RE: 6/2023/1354/COND – 71 Station Road, Cuffley, EN6 4HG.

I am writing in response to the letter dated July 14, 2023, from the Lead Local Flood Authority (LLFA) regarding Condition 4. I would like to address the points raised as follows:

APPR	DRAWING NO	REV
	2592-05	C

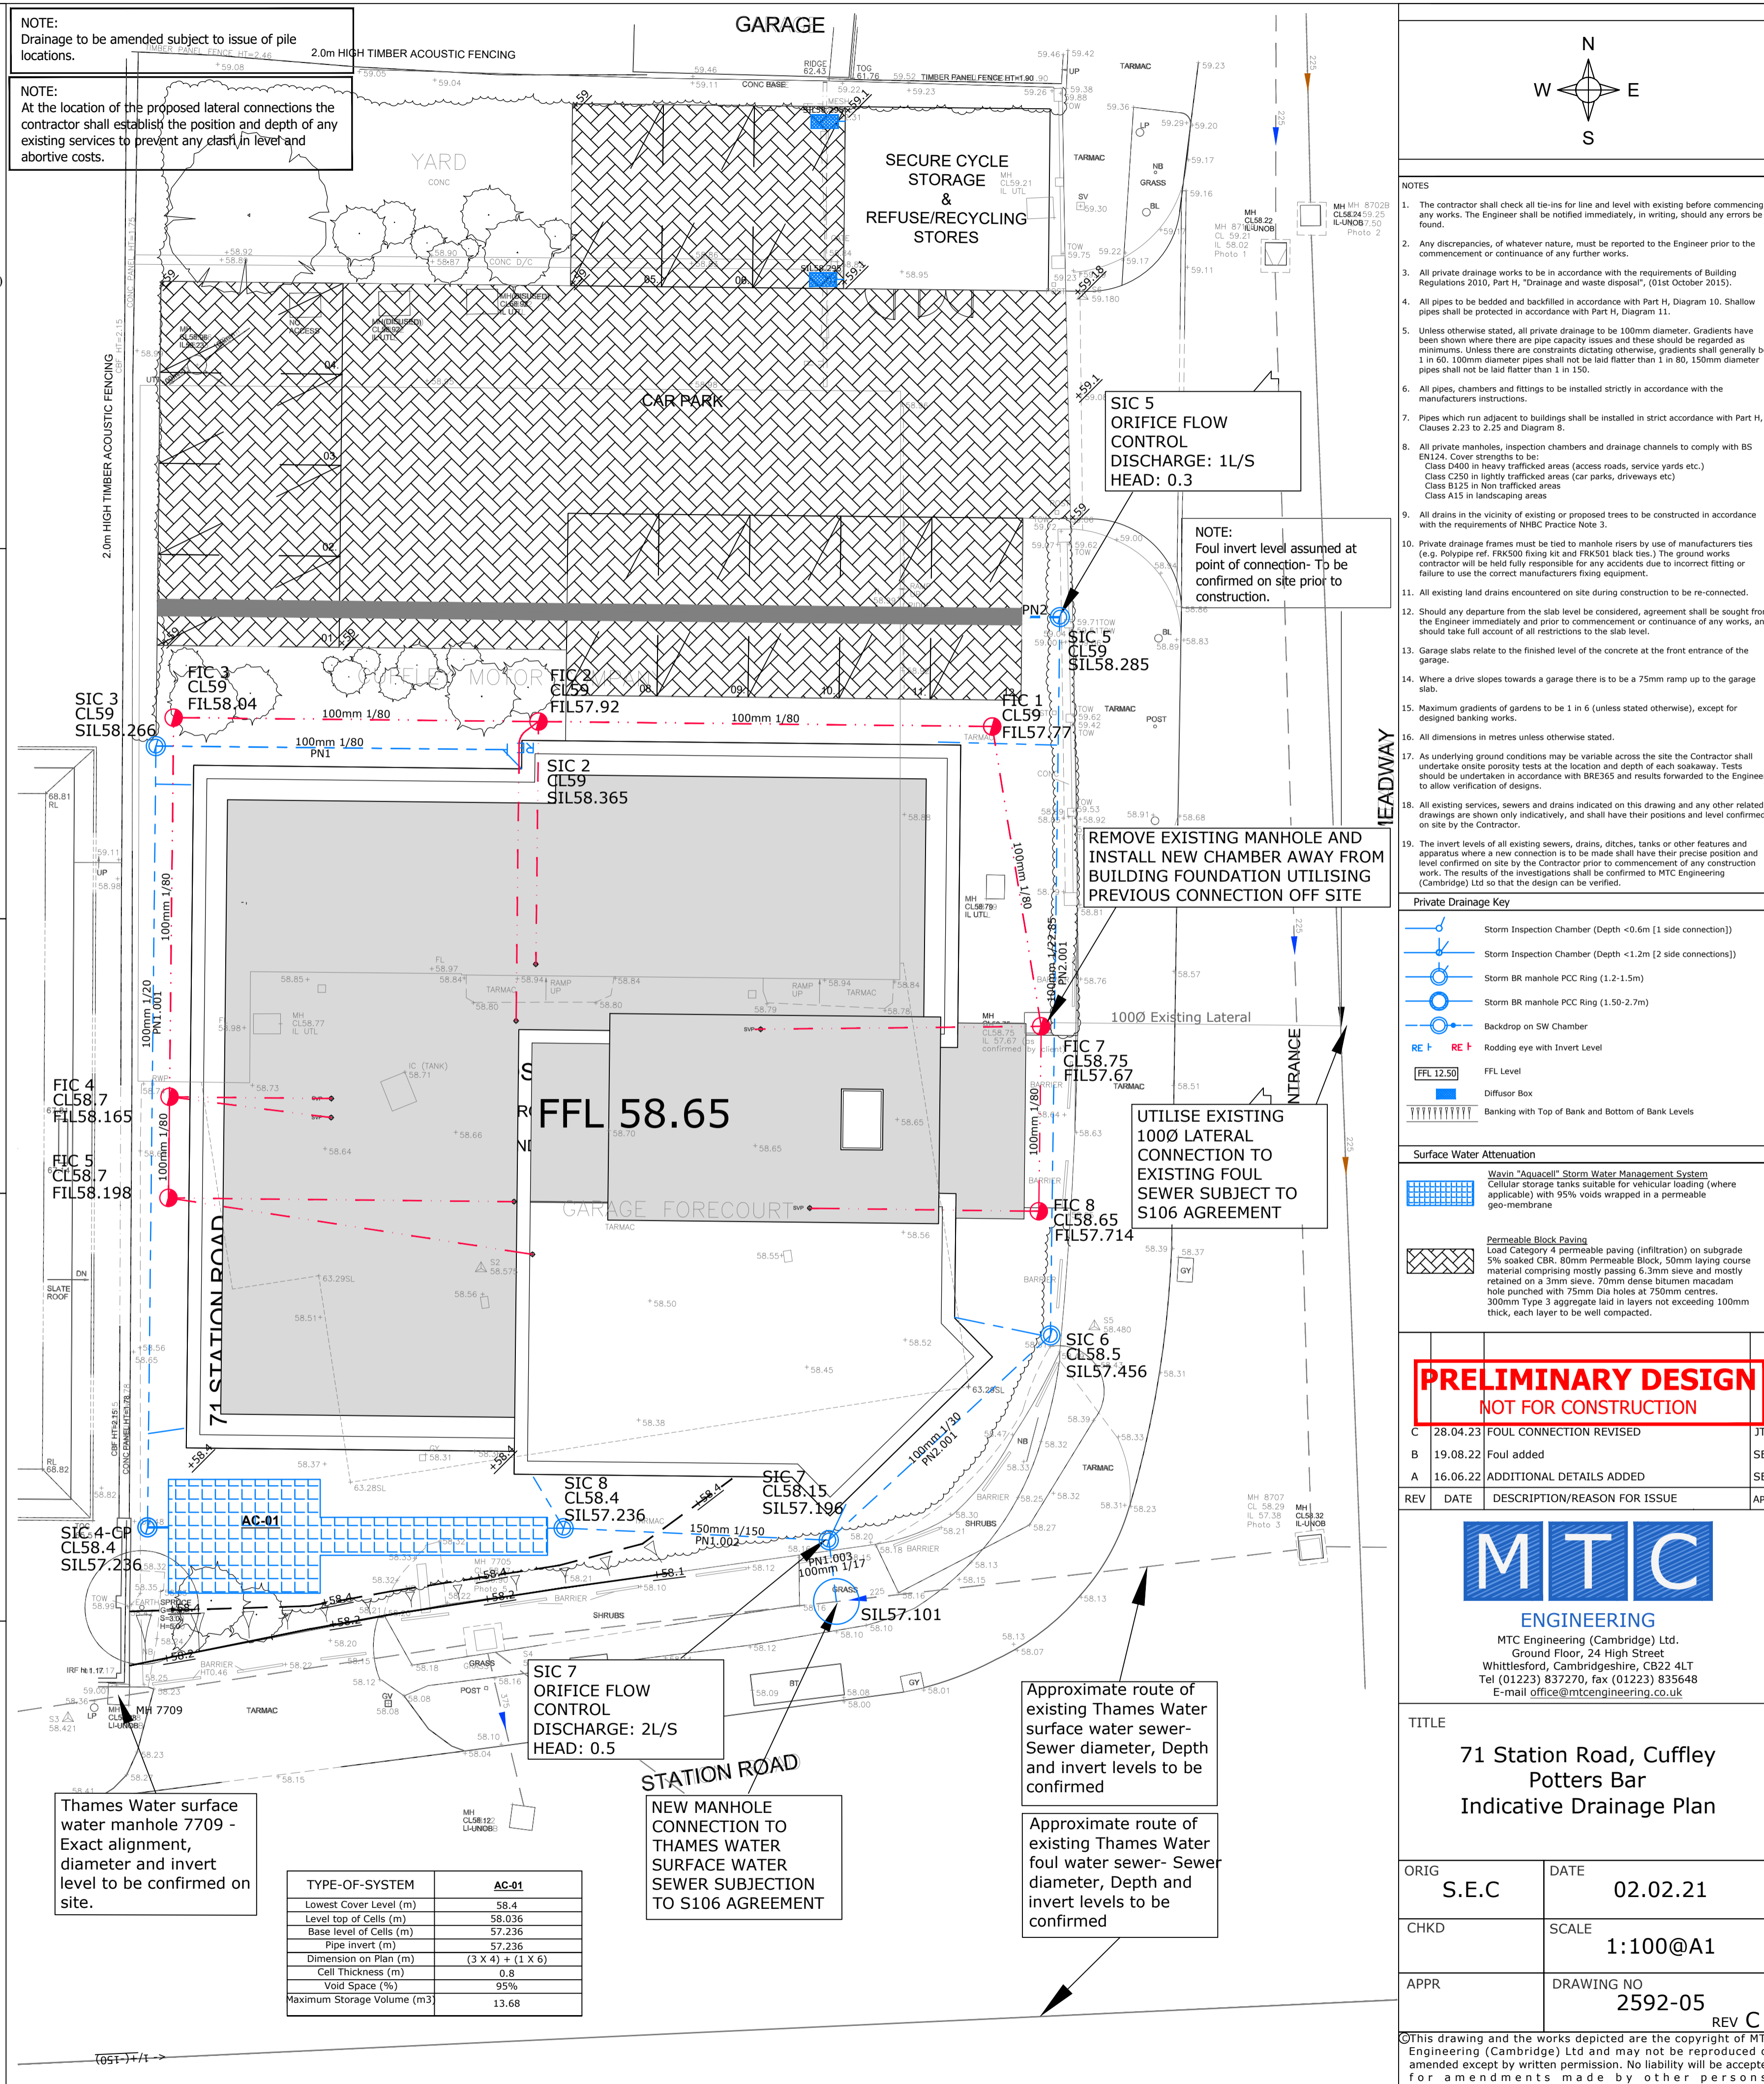
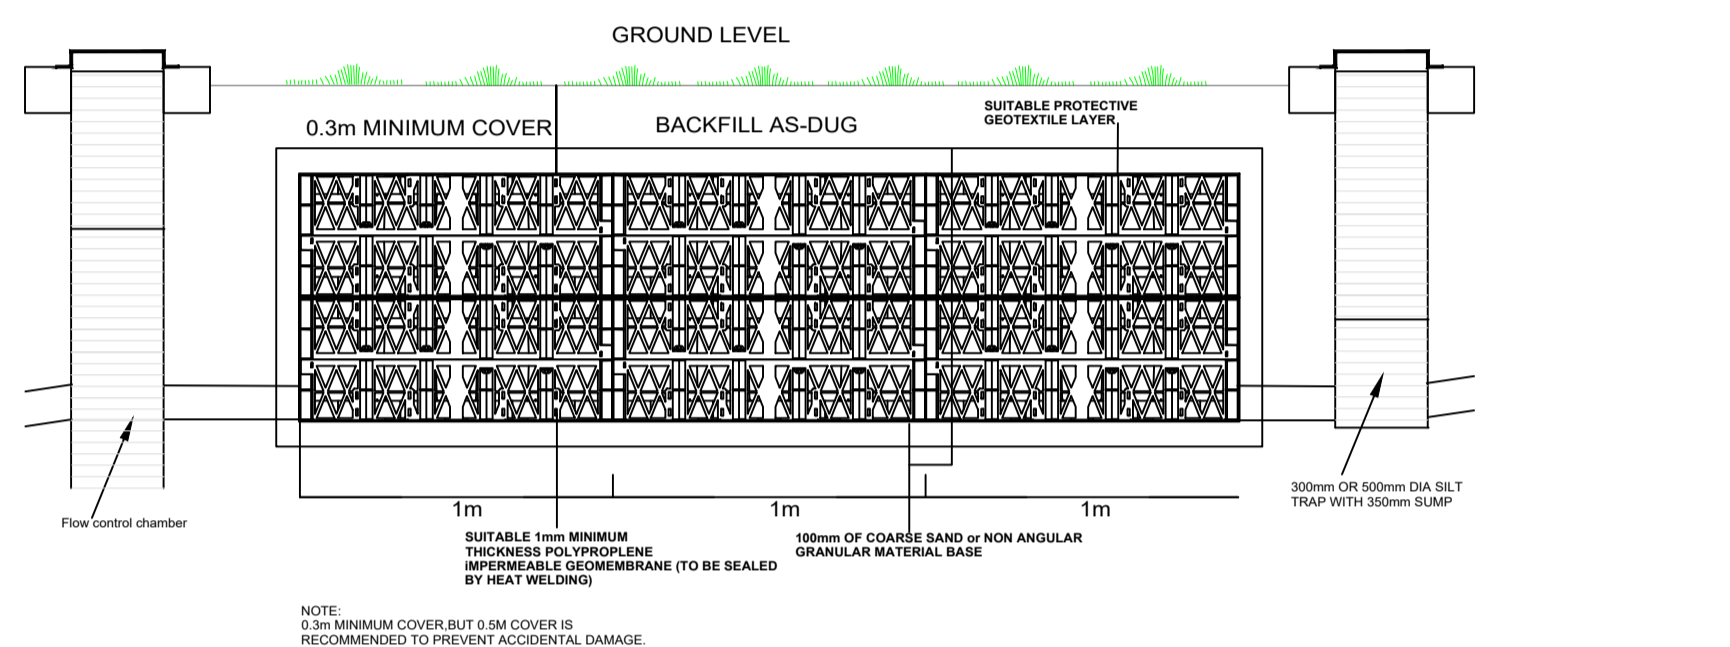
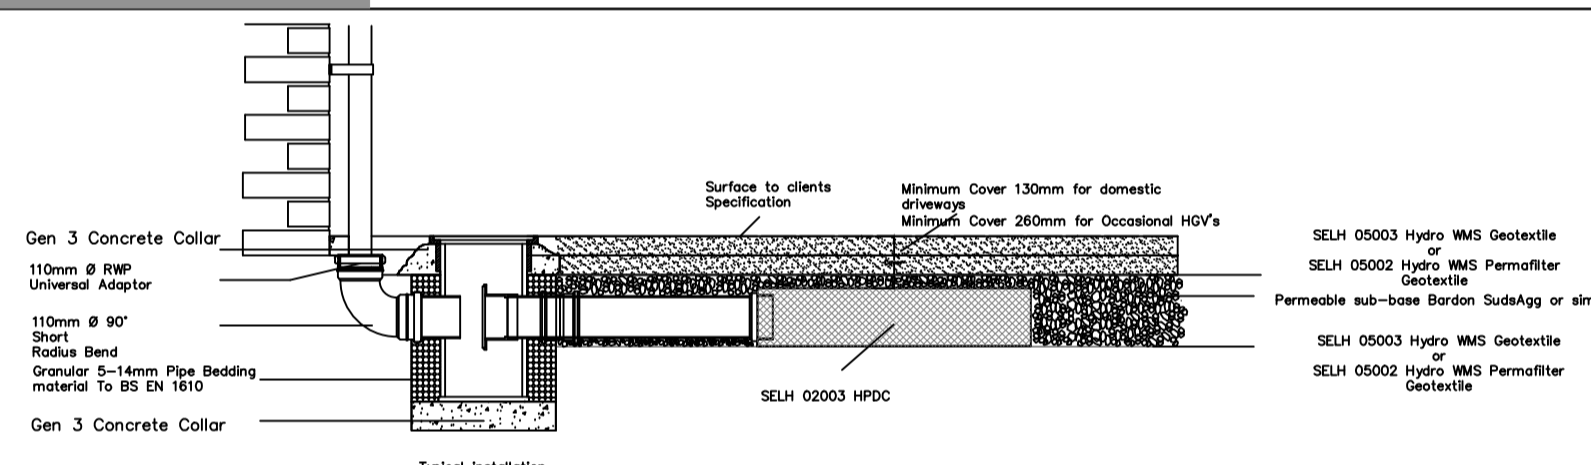
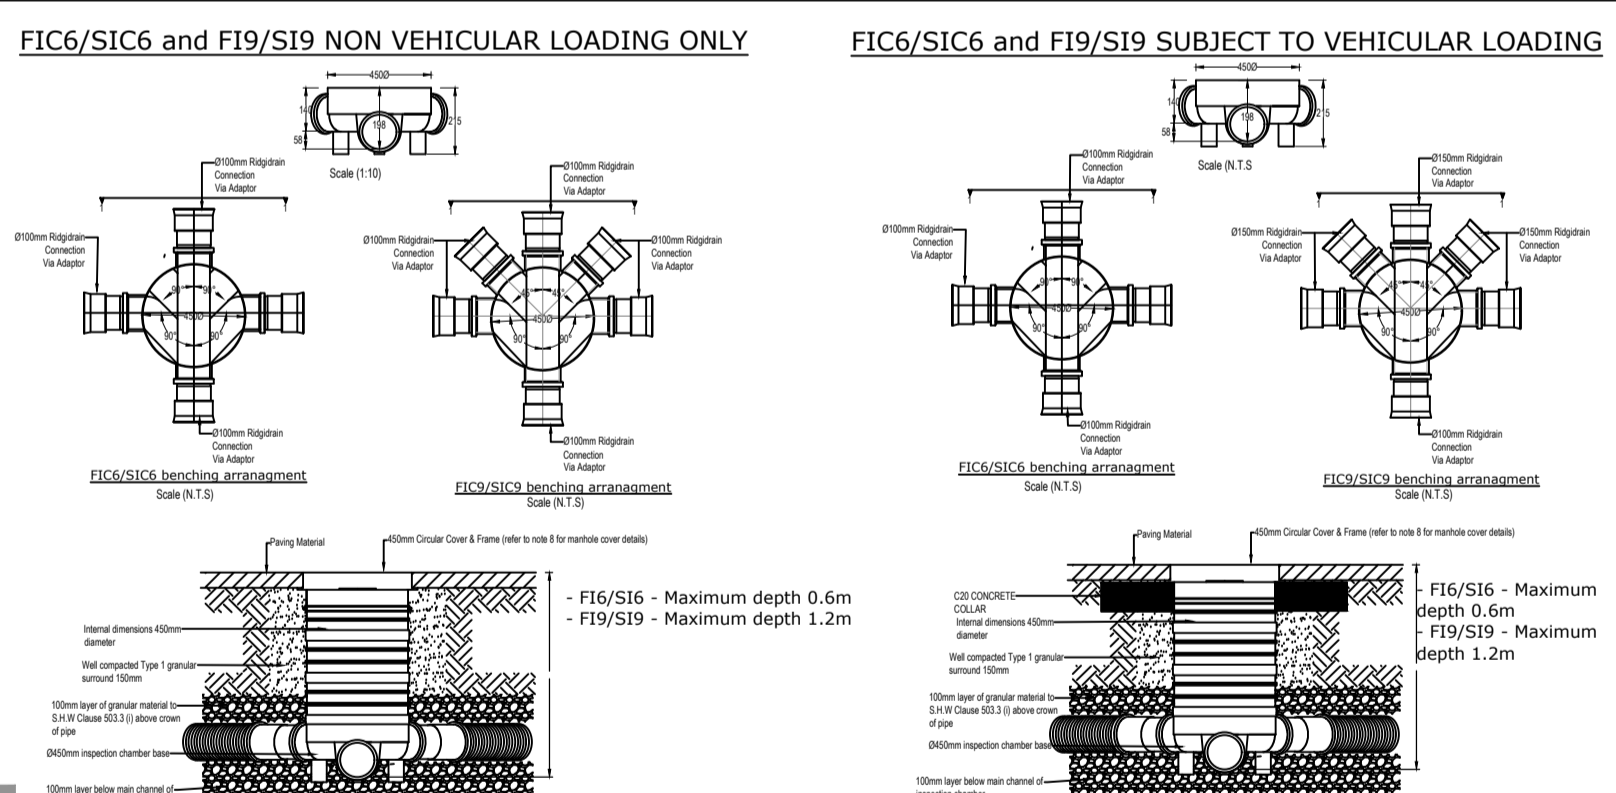
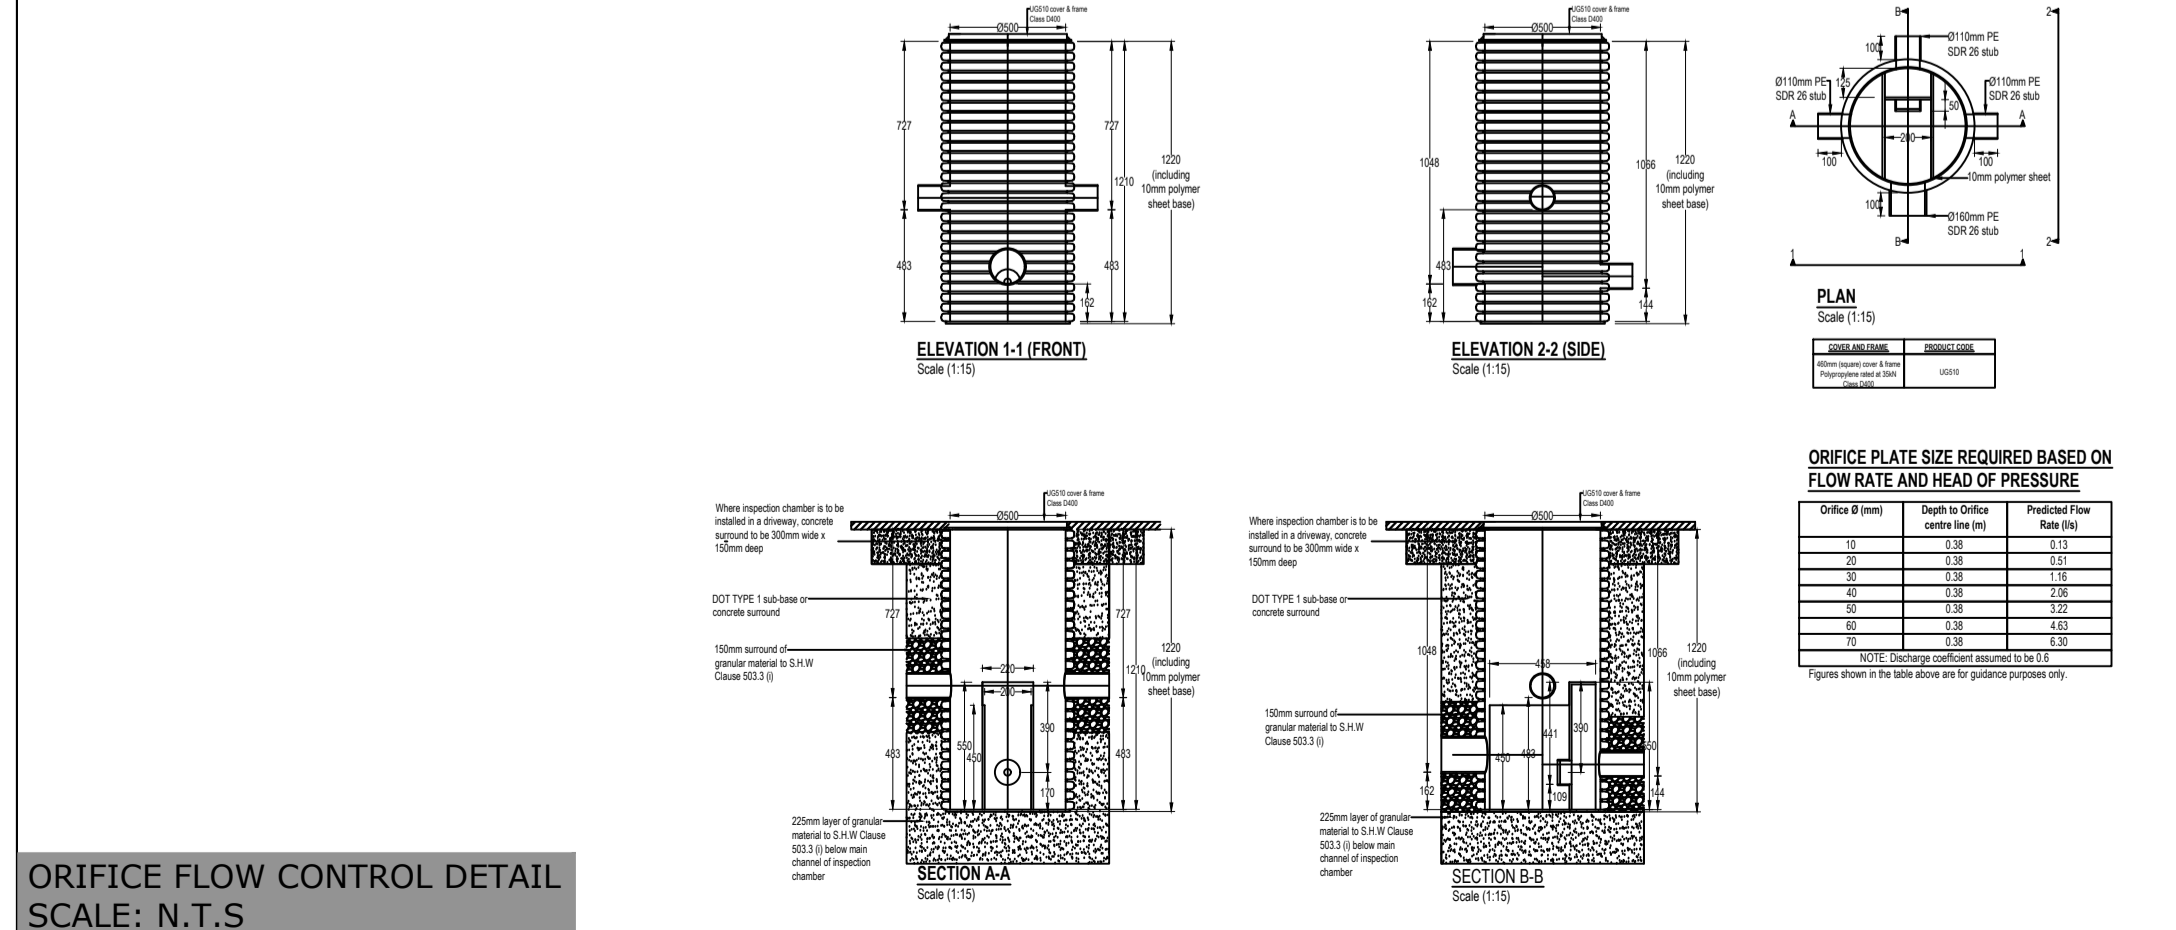
- h. Silt traps have been clearly indicated on our drawings. We encourage the LLFA to review these drawings carefully to locate the relevant information.
